From: alan.story@hertfordshire.gov.uk
To: [Planning](#)
Subject: Planning application 6/2018/3255/FULL - Plot 5610
Date: 28 January 2019 15:44:09

Response to Planning application from Hertfordshire County Council (T and CP GDP Order 2015)

District ref: 6/2018/3255/FULL

Erection of a pre-delivery inspection facility (Use Class B8), together with car storage area, staff car parking, cycle parking, boundary treatment, landscaping, lighting and access

6434 - 008
 PLANNING

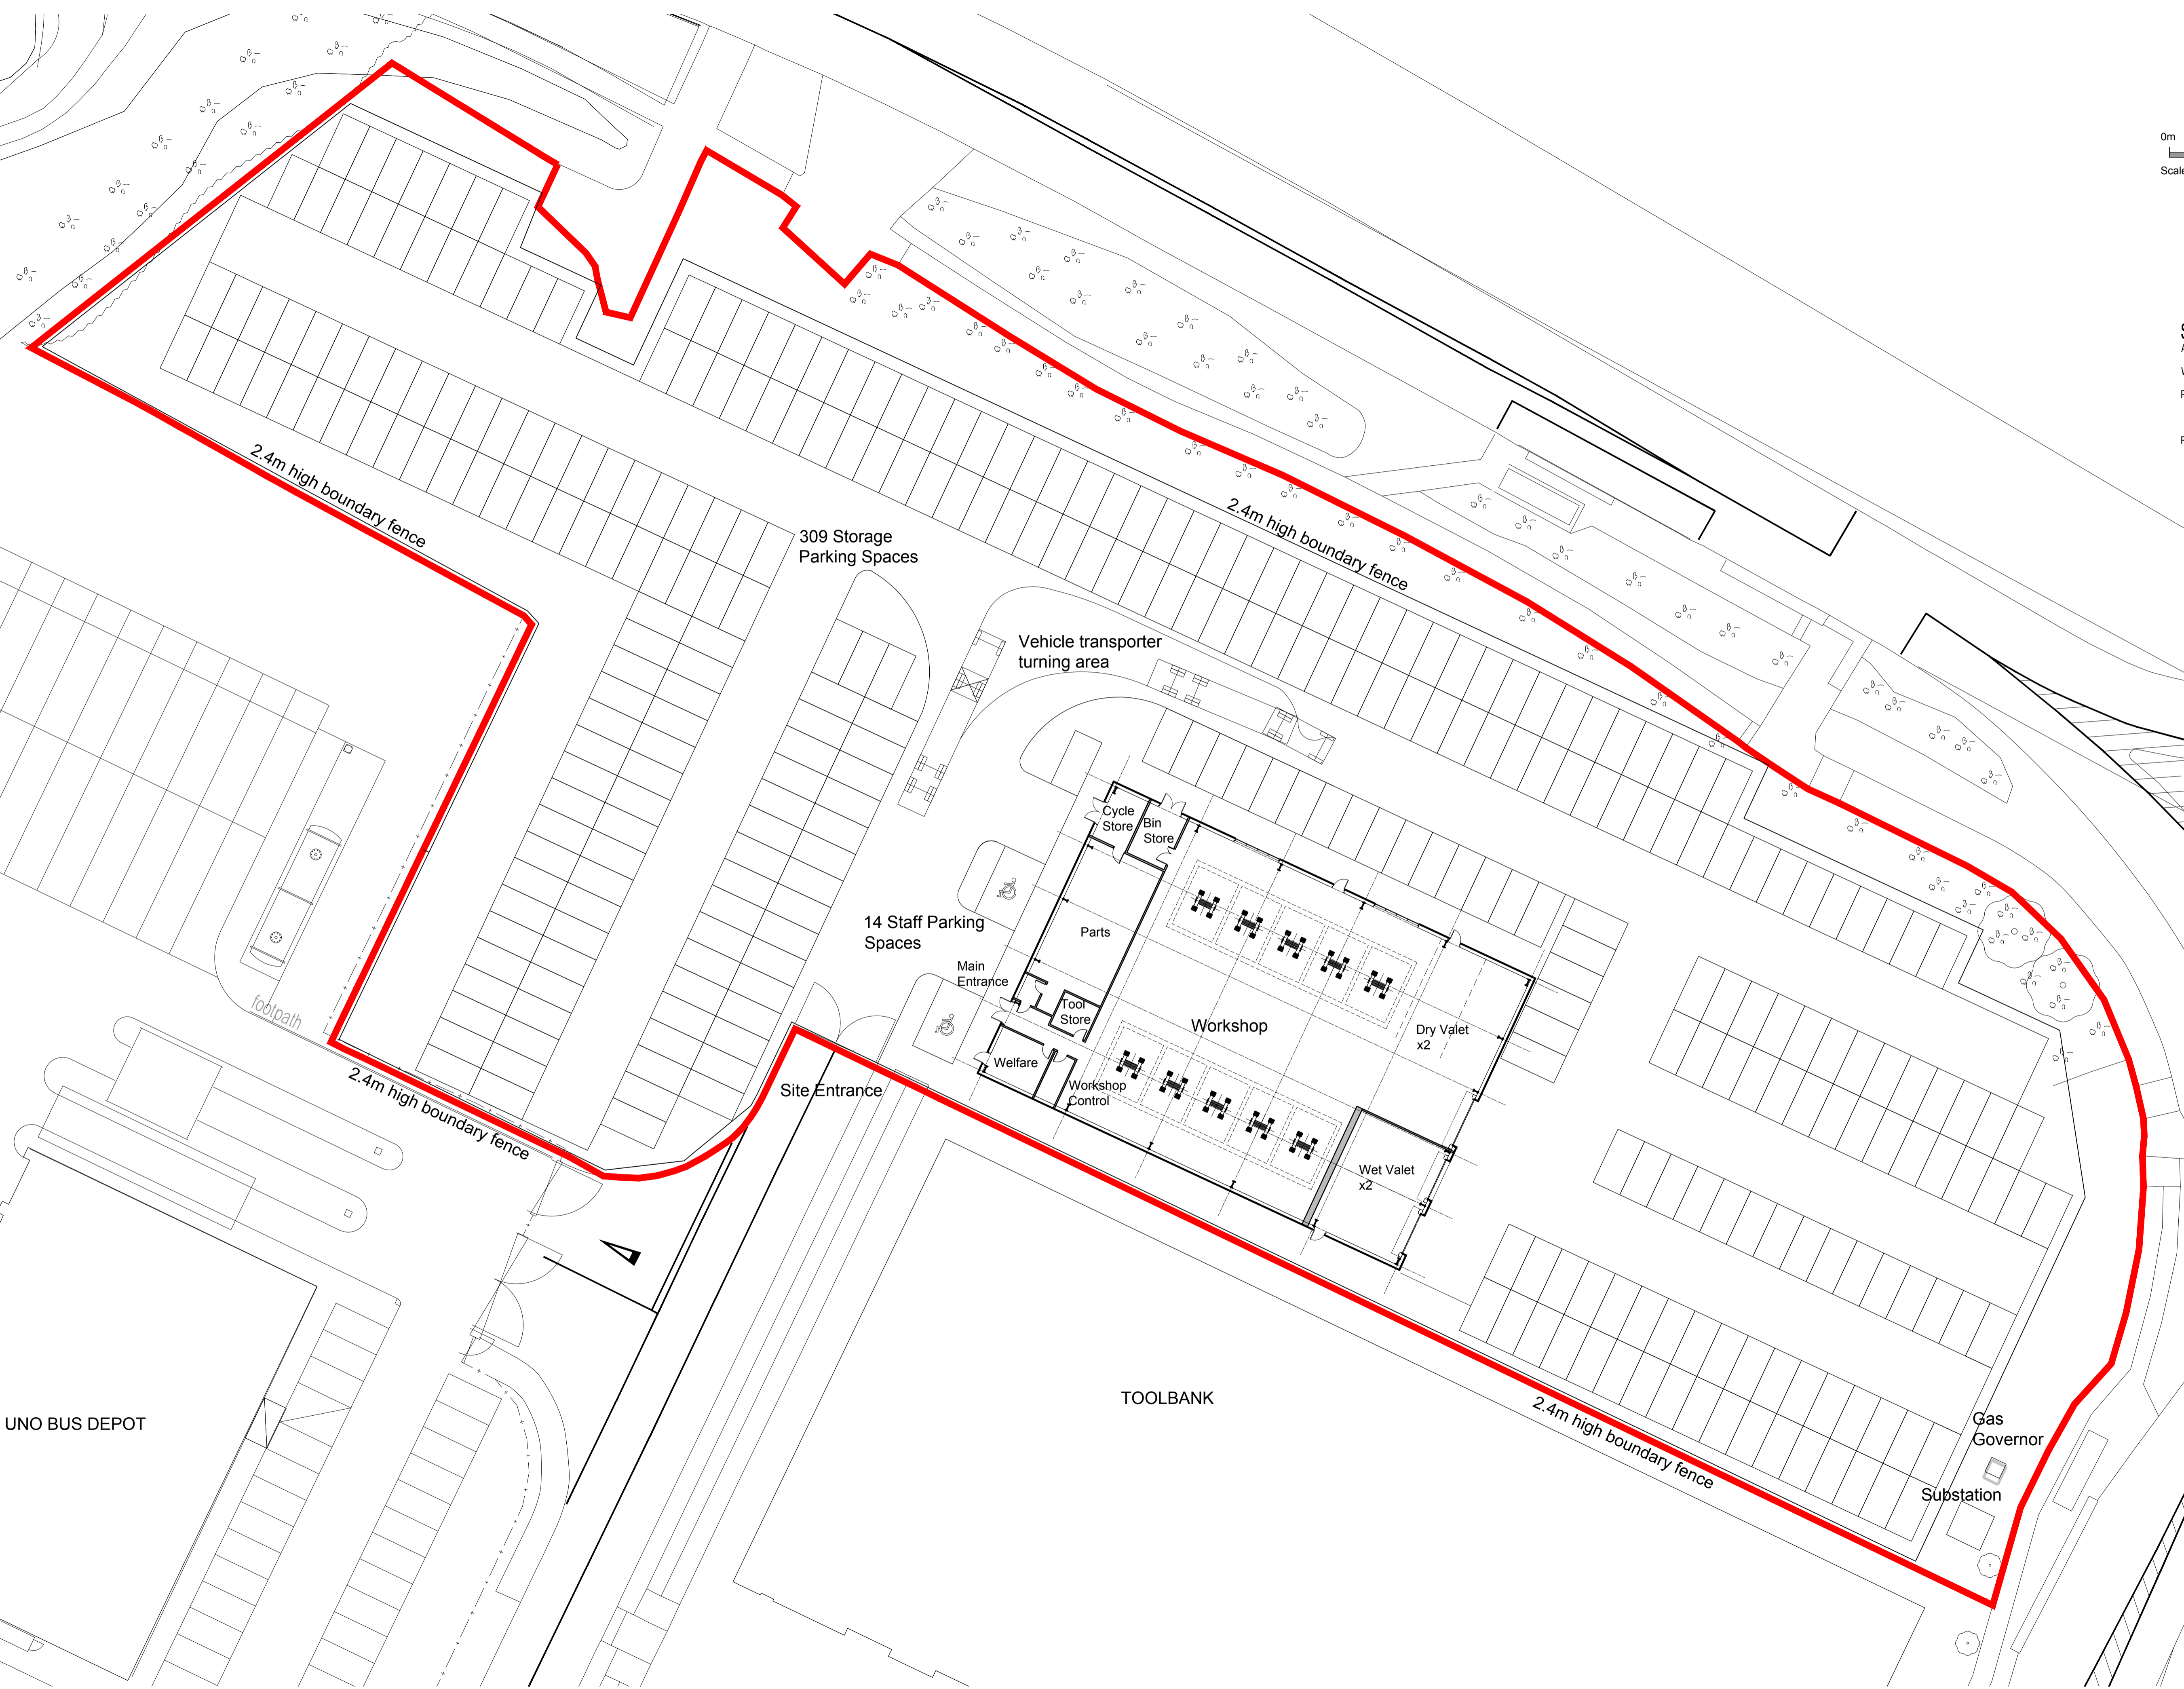
The site is appropriately laid out to accommodate the turning movements of pantechnicon vehicle transporters (drawing 6434-008) sufficient that deliveries of vehicles to the site prior to leaving in forward gear.

Site layout provides parking, to a total of 323 spaces (drwg 6434-008) such provision is shown as 14 staff spaces (inc 2 accessible spaces) with the remaining 309 spaces as operational parking, and is arranged (in the main) in a tandem pattern consistent with the storage of vehicles in the medium term.

The parking – for staff – is provided at a level of 14 spaces, the LPA shall wish to consider this against the Hatfield Aerodrome SPG which appears to suggest that be the latter phases of development parking should be limited to 1 space per 100m² of B8 use, and therefore would indicate compliance with the SPG shall be 10 spaces. I do not consider, in highway terms, that the provision of parking for staff / visitors at the level proposed would have a significant affect on the trip generation of the site.

All areas for parking should be constructed such that they do not drain into the highway. It is recommended that all areas for parking are retained for that use only, with the distinction between staff parking and operational parking.

1) Prior to the first use of the development hereby permitted the proposed access / onsite car parking / servicing / loading, unloading / turning /waiting areas shall be laid out, demarcated, levelled, surfaced and drained in accordance with the approved plan and retained thereafter available for that specific use. Reason: To ensure construction of a satisfactory development and in the interests of highway safety in accordance with Policy 5 of Hertfordshire's Local Transport Plan (adopted 2018).
